Planning Application No: 3/2025/0980

Proposal: Regularisation of conversion of garage to living space with new window and door.

Location: 33 Shipton Road Clitheroe BB7 2RZ

Scale 1 - 100 Proposed Drawings

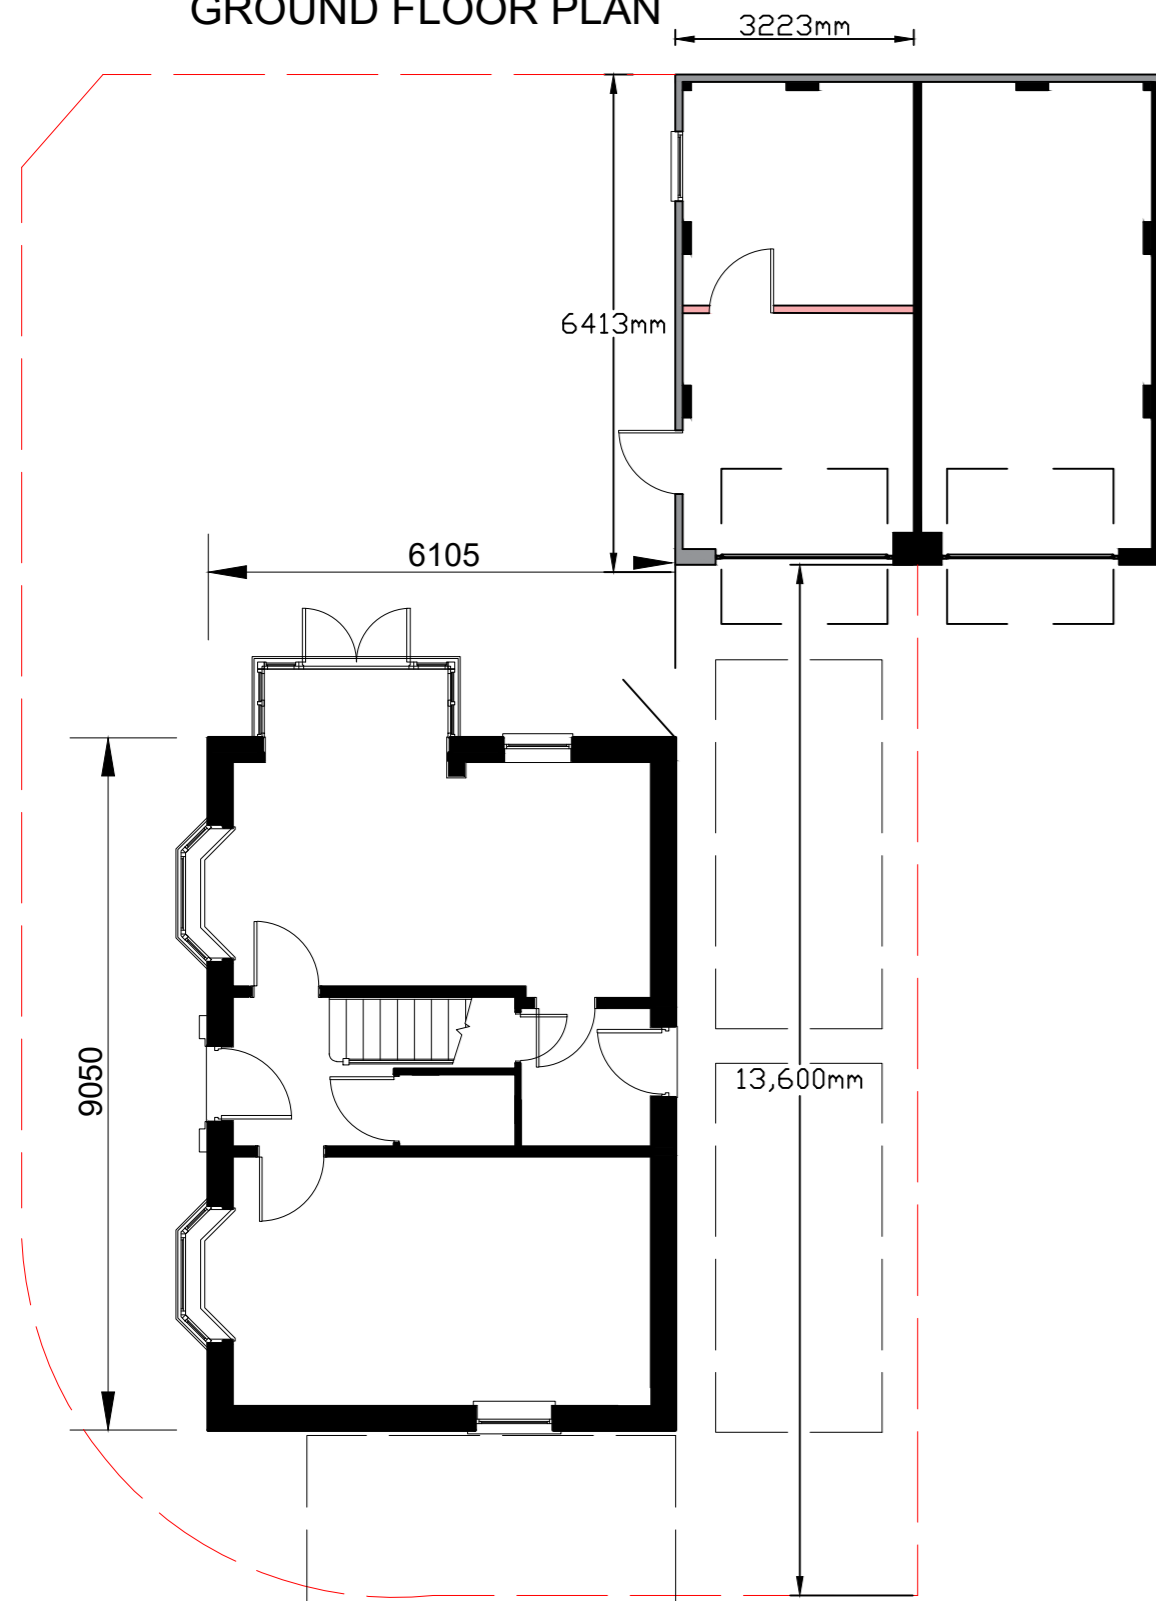
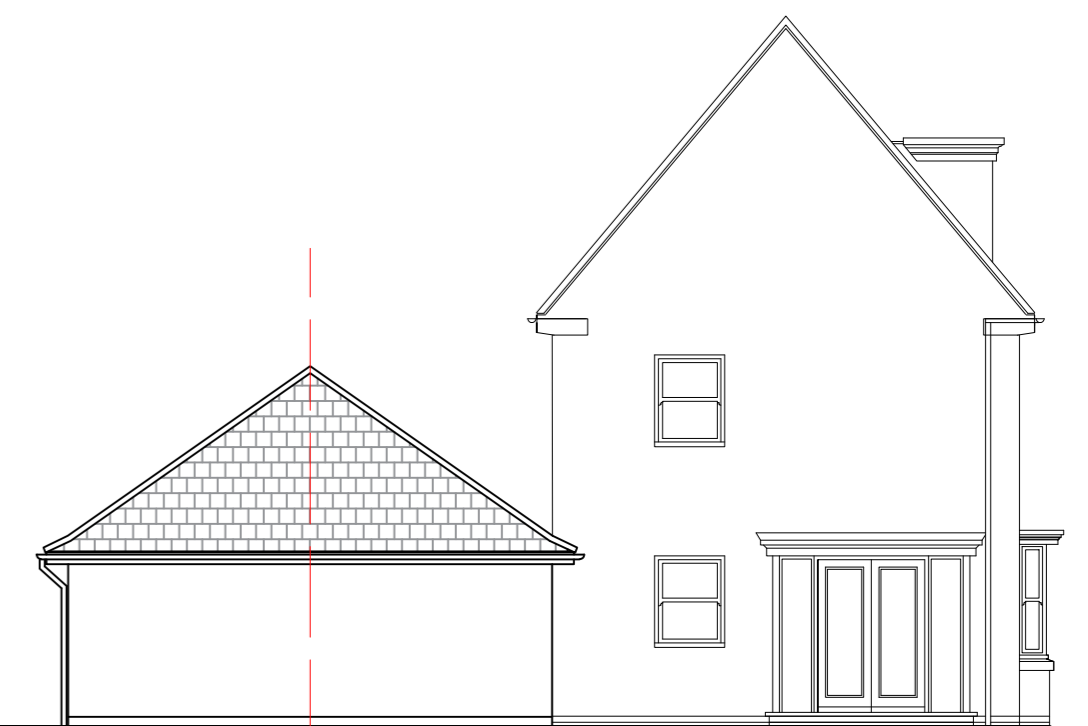
It is noted that this is a retrospective application. There is no mention of number of bedrooms with this proposal, however, 2 parking spaces can be provided on the drive. Providing these meet parking standards requirements for the dwelling size ie 2 or 3 bedrooms, then there is no highway objection.
